Remediation of 2 Christina Road Villawood, NSW – Environmental Assessment Submissions Report

November 2011

Prepared for:
Orica Australia Pty Ltd

Figure
2

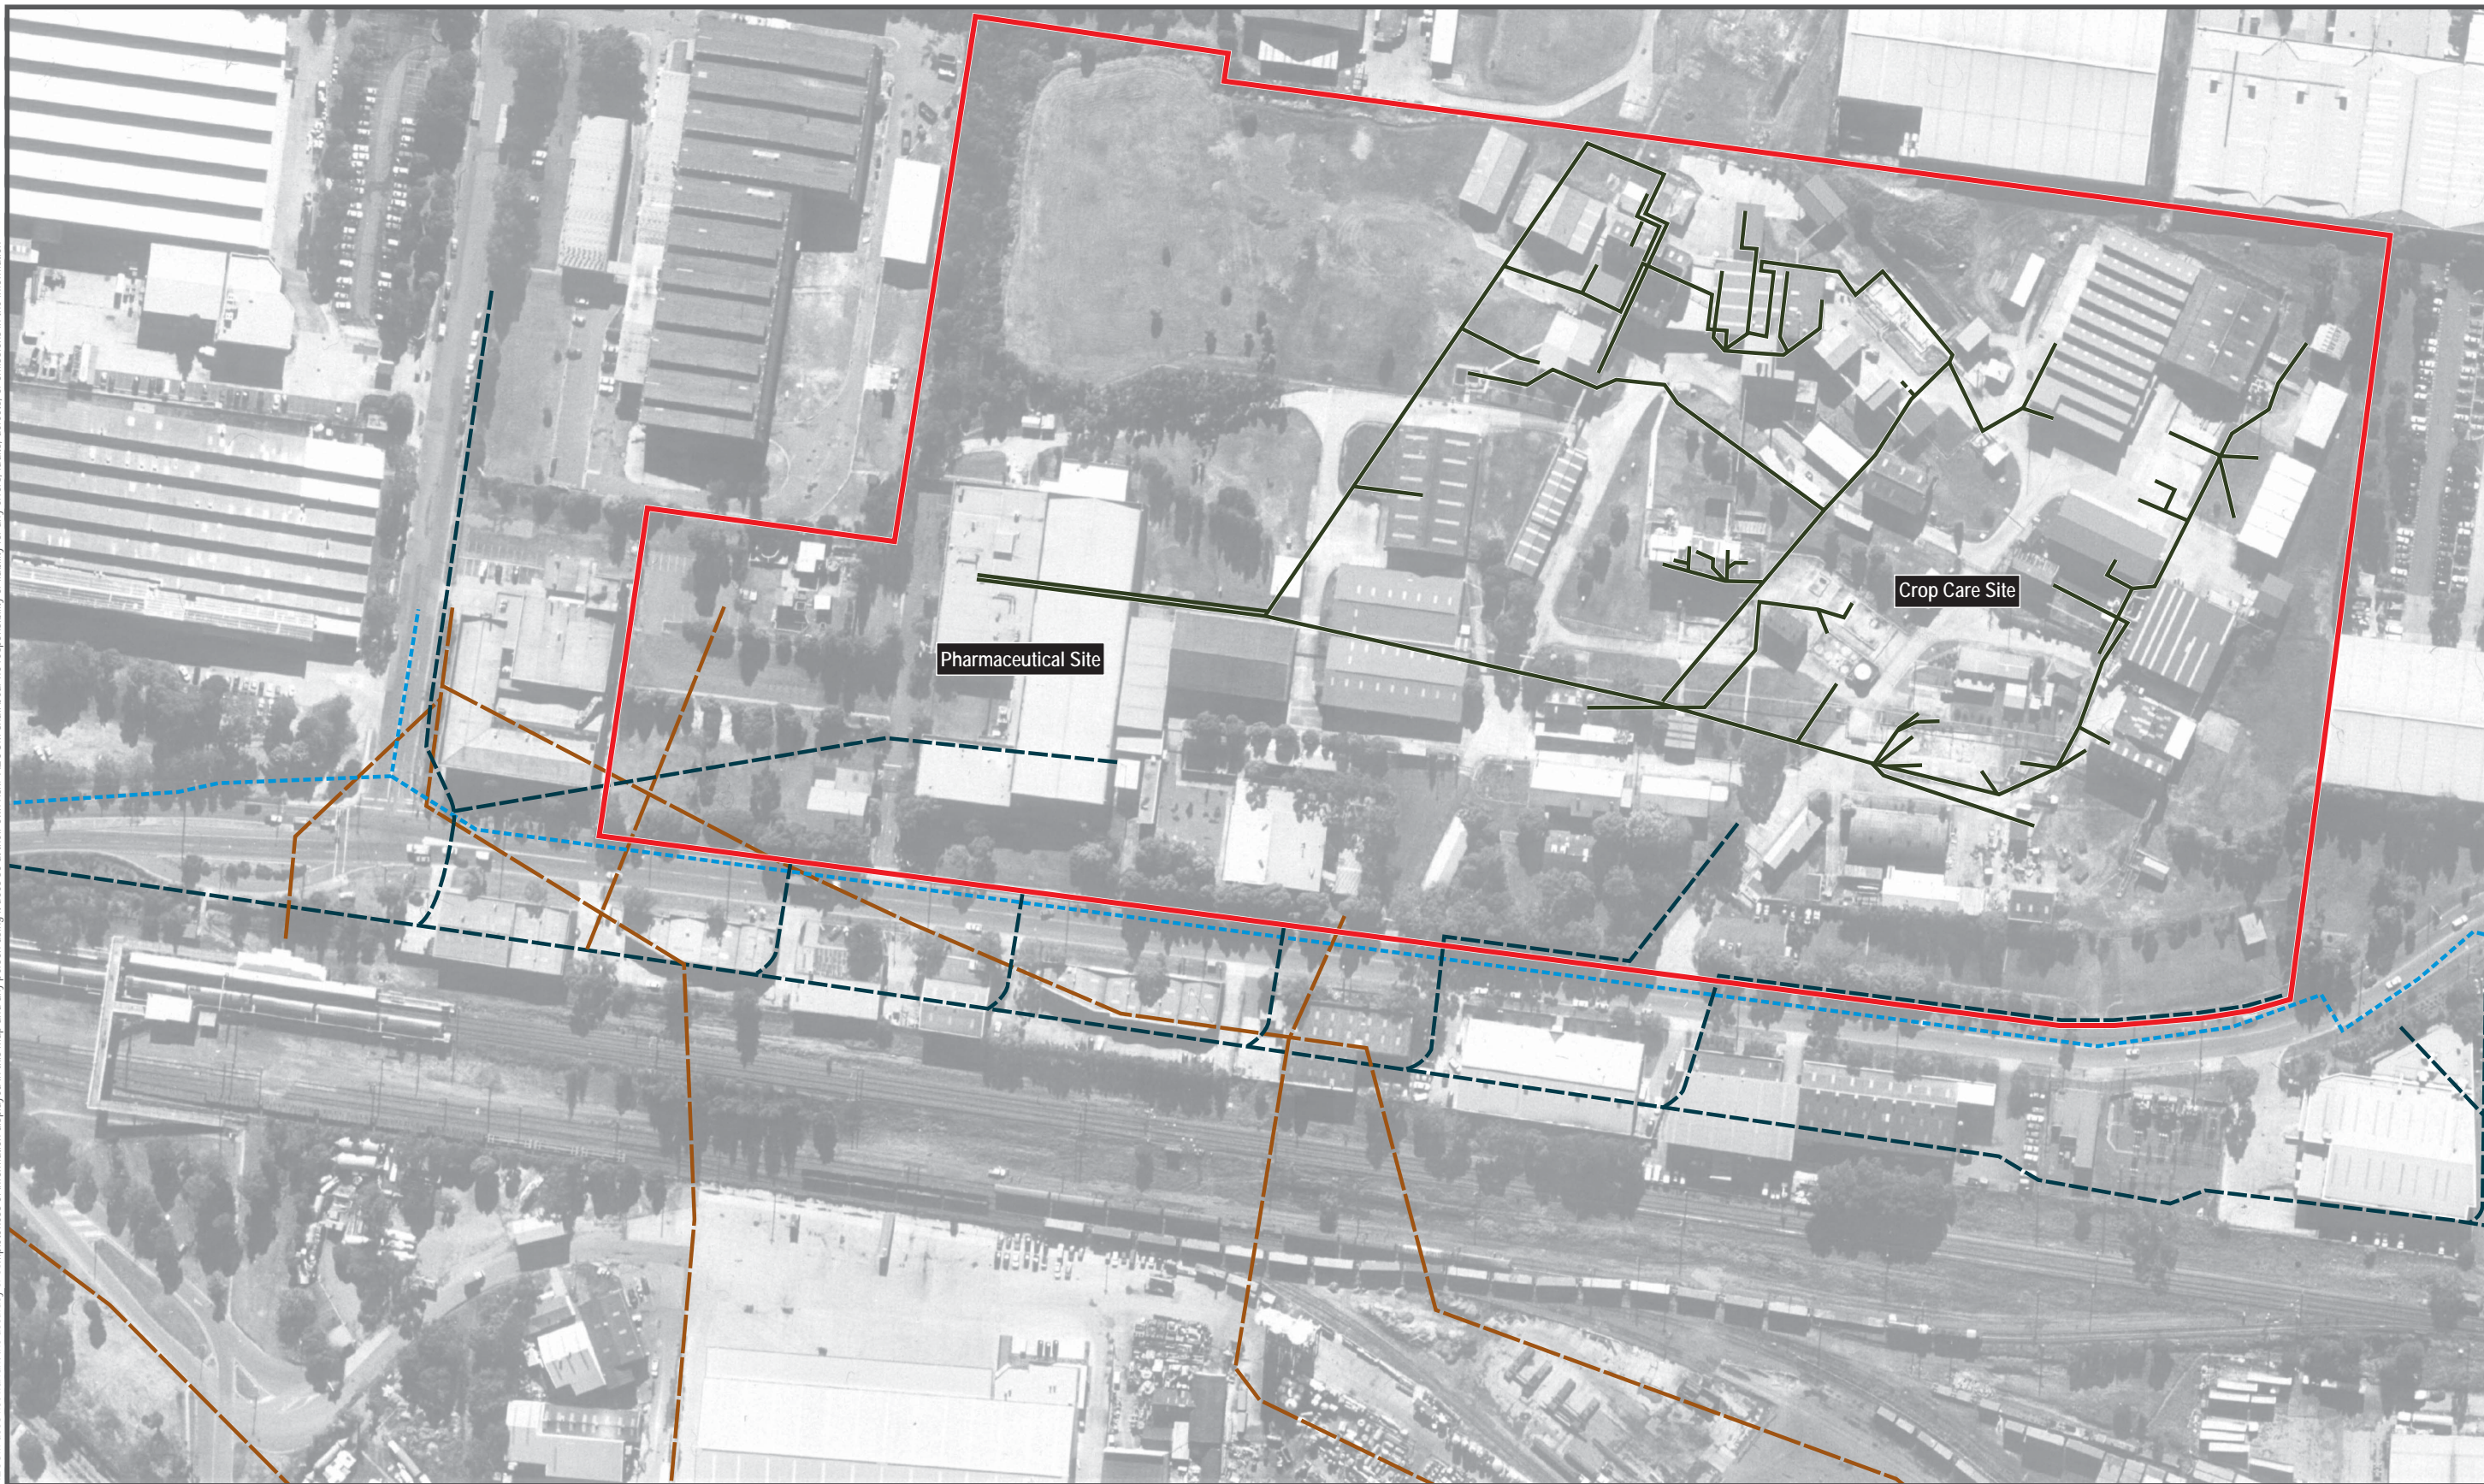
Ref. No.	Requirement	EA Reference/ Comment
	Report errors: - Figure 2 is stated (p3) as showing the source zones summarised in Table 1, however Figure 2 only shows the 8 contaminated soil source areas (Source ID's). - Volume of Pre-treatment stockpile in Appendix A should be 25,760 (not 15,760). - Estimated volume of soil is 26,540m³, however DTD estimate of 165m³/day soil for 156 days gives only 25,760m³ of treated soil. - Justification is lacking in the AHRA why "the maximum mean soil chemical concentration over all sources" (in the determination of volatile chemical emission rates) was used for the assessment rather than the maximum soil concentration measured. The Proponent has proposed to manage fugitive volatile emissions and odours from stockpiles by covering them using a range of methods including clean soil, spray grass, odour suppressant sprays or foams. This is of concern to OEH as previous experience has shown these methods to be ineffective in managing fugitive emissions and odours from stockpiles. The OEH will require the Proponent to cover stockpiles as a condition of the Environmental Protection Licence using covers such as HDPE plastic sheeting or tarpaulins to provide more effective emission control.	Noted Section 3.4.2
